CADIA HOLDINGS PTY LTD
CADIA EAST PROJECT – RESPONSES TO GOVERNMENT SUBMISSIONS

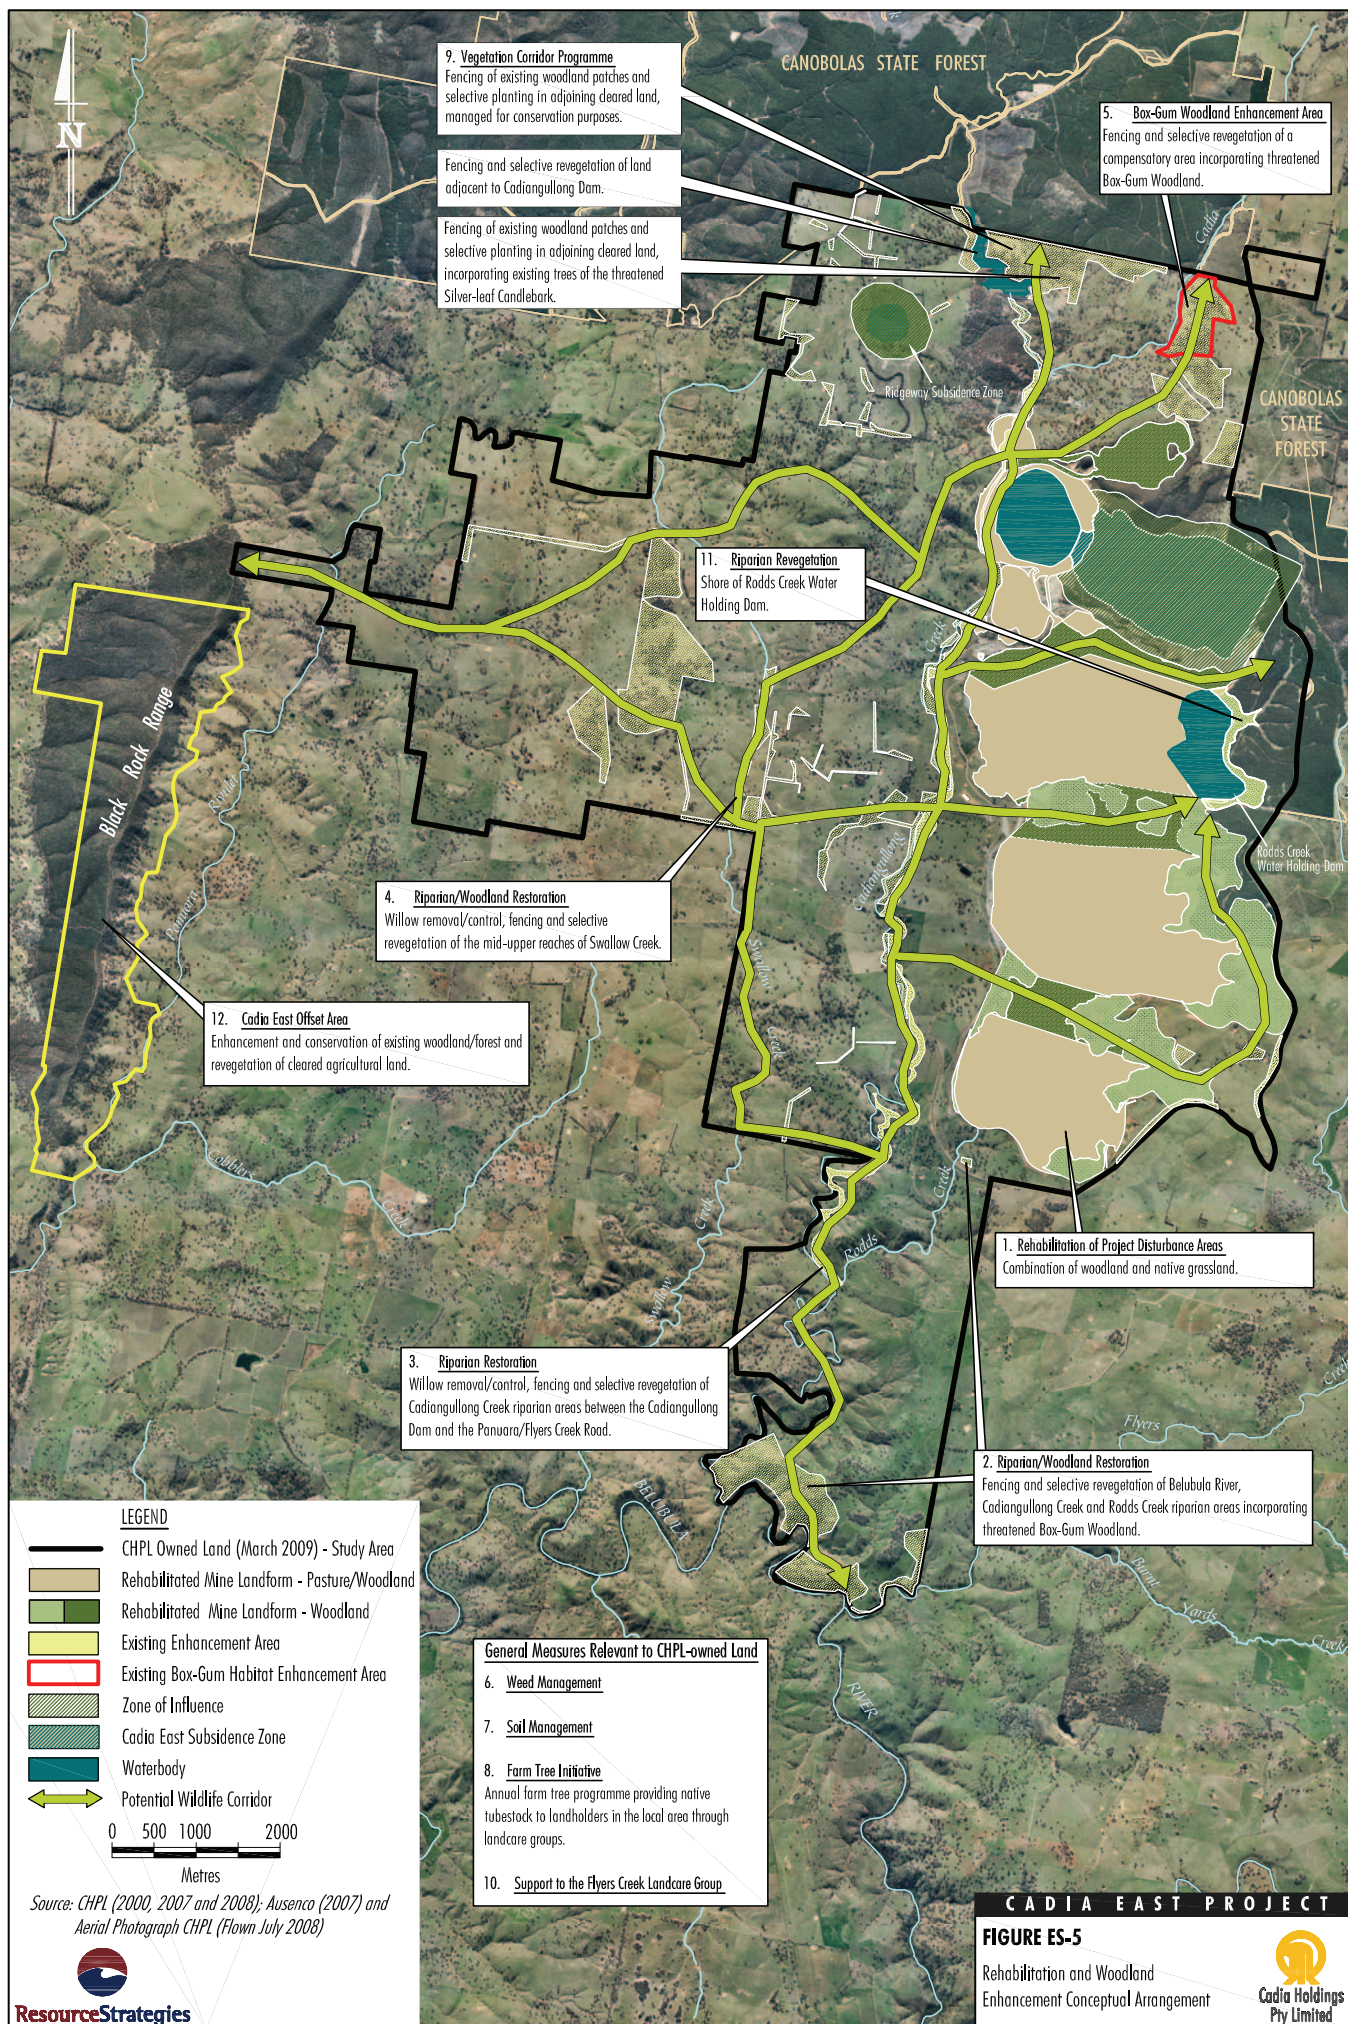
Government Agency/Local Government Authority	Issue Raised	CHPL Response
Department of the Environment, Water, Heritage and the Arts (Commonwealth) (Con't)	Does Figure 4-24 show the most up-to-date boundary for the proposed offset area? If not, please provide the most recent map showing the current boundary. Is the location of the boundary expected to change in the future? In 1st paragraph, 56 ha of state-listed box gum grassy woodlands is intended to be 'enhanced' to meet the Commonwealth listing criteria how is this area proposed to be enhanced? That is, what measures are proposed in order to improve the quality of these areas? In 3rd paragraph, 173 ha of agricultural land is proposed to be revegetated. What measures are proposed to revegetate this area?	Yes. This is the proposed offset for the Project and the concept is supported by CHPL and the background landholder of the property 'Ulah' (the property incorporating Black Rock Range). The final boundary locations would be subject to survey prior to contracts being exchanged with the background landholder of the property 'Ulah'. A broad description of the proposed measures to be used enhance the quality of these areas is provided in Section 4.4.3 of the EA. In particular, it states that: <i>A management plan would be prepared by a suitably qualified person(s) to facilitate the revegetation and regeneration of native vegetation and habitats and provide a framework for continued management and monitoring.</i> ... <i>The plan would describe measures including, but not necessarily limited to:</i> <i>provision of appropriate fencing to exclude grazing from the remainder of the Ulah Property (the background landowner of Black Rock Range) thereby assisting natural regeneration;</i> <i>native revegetation plantings using a local seed source;</i> <i>removal of unnecessary existing fences to facilitate fauna movement;</i> <i>soil erosion management;</i> <i>weed and pest management;</i> <i>fire management measures to include irregular mosaic burnings;</i> <i>signage of the offset area;</i> <i>restriction of vehicular and people access; and</i> <i>monitoring, auditing and reporting the performance of the offset</i> The management plan would be prepared in consultation with the relevant government agencies, including DEWHA, and would include specific details of plant species to be used, timing of activities, monitoring and reporting. The Fauna Assessment provided in Appendix A of the EA, states the conservative area of potential habitat for EPBC listed fauna species (ie. the entire area of woodland is conservatively considered to be potential habitat for EPBC listed fauna species). For both the Superb Parrot and Swift Parrot, Appendix A of the EA states: <i>'The various patches of remnant vegetation communities/habitat that would be disturbed for the Project equate to a total area of approximately 238 ha.'</i>
